STATE OF NORTH CAROLINA
DEPARTMENT OF TRANSPORTATION

April 1, 2015

SUBJECT: **Request for Modification of the Section 404 Individual Permit, Section 401 Water Quality Certification, and Neuse River Riparian Buffer Authorization** for the proposed East End Connector from NC 147 (Durham Freeway/Buck Dean Expressway) to north of NC 98 (Holloway Street) in Durham, Durham County, North Carolina, Division 5. Federal Aid Project No. NHF-76-1(2), TIP No. U-0071.

In addition to this cover letter, please find enclosed the revised Division of Mitigation Services (DMS) (formerly EEP) Acceptance Letter, revised Wetland Permit Drawing Sheet Nos. 20, 21, 36, 37, 60, 61, 74, 75, 90, and 91 of 91 and Buffer Permit Drawing Sheet Nos. 5 through 7 and 18 of 18.

Permit Drawing
 Sheet 36 of 91

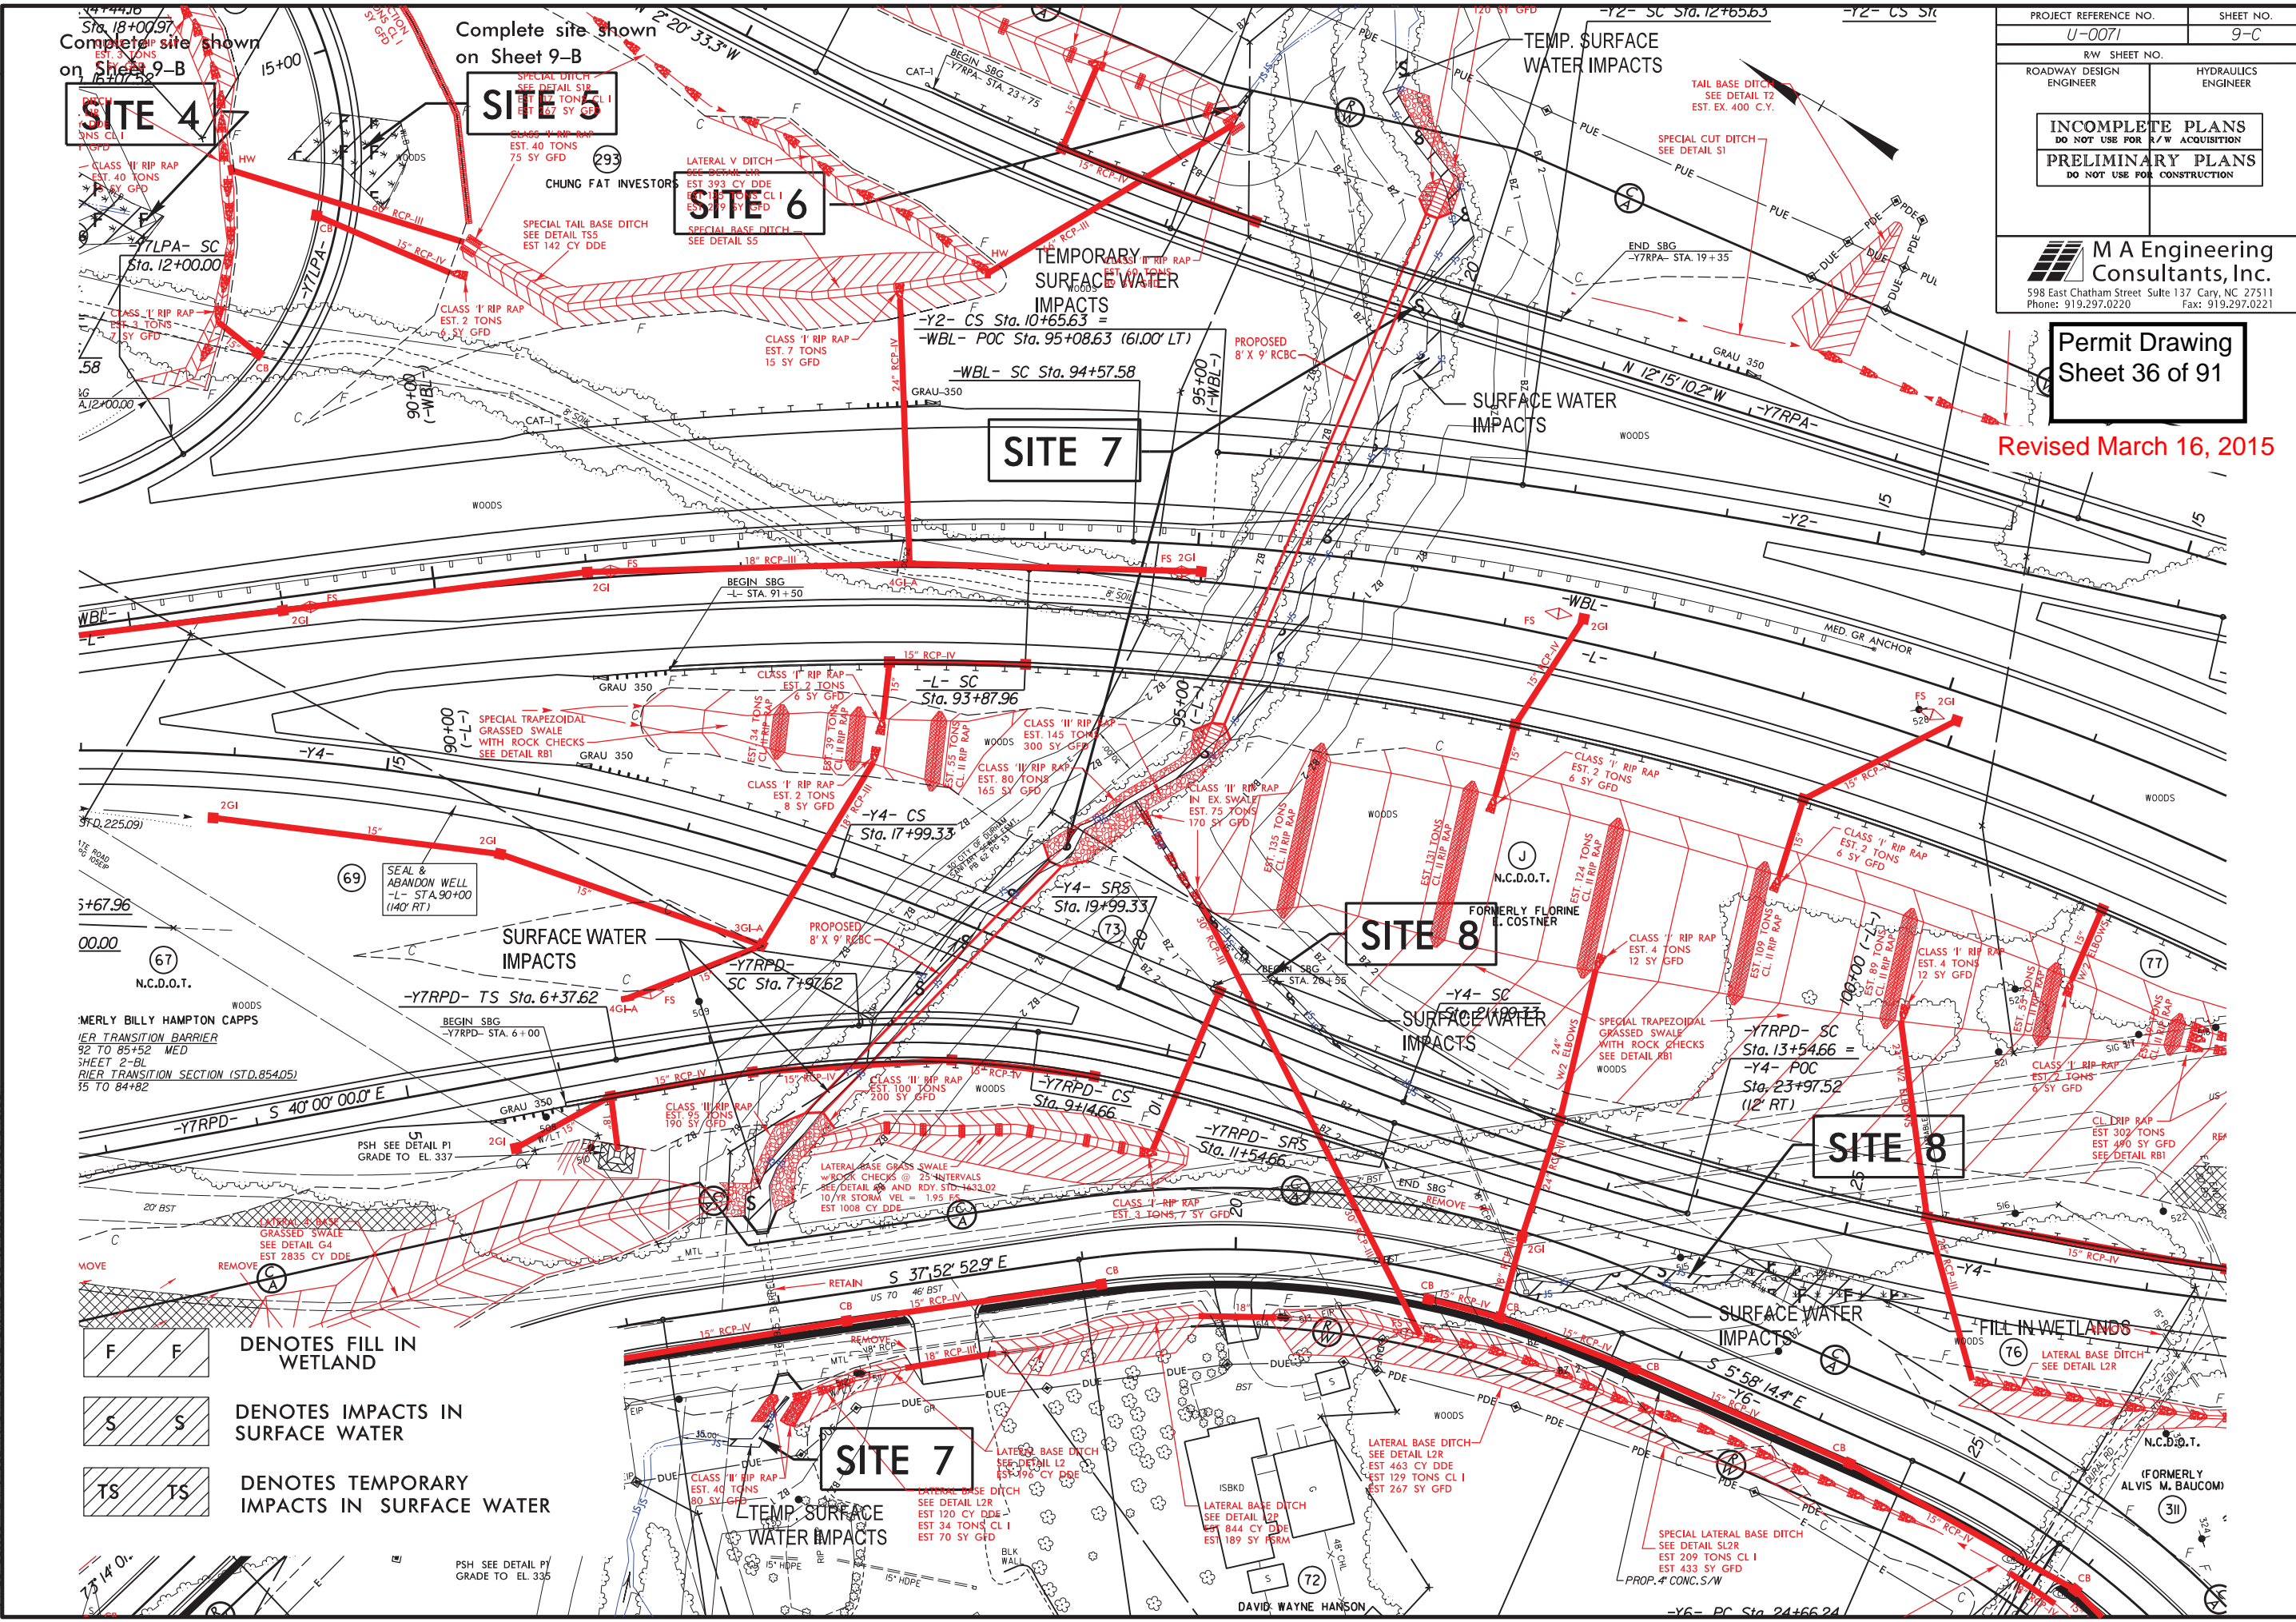
- Site 7: A review of the culvert construction sequence indicates that the tie-in point of the temporary diversion channel at the culvert inlet is located outside of the permitted stream impact footprint. Additional stream impacts are necessary at this site to install the temporary diversion channel at the culvert inlet. There will be a reduction in temporary stream impacts of 6 linear ft. and an increase in bank stabilization of 55 linear ft.
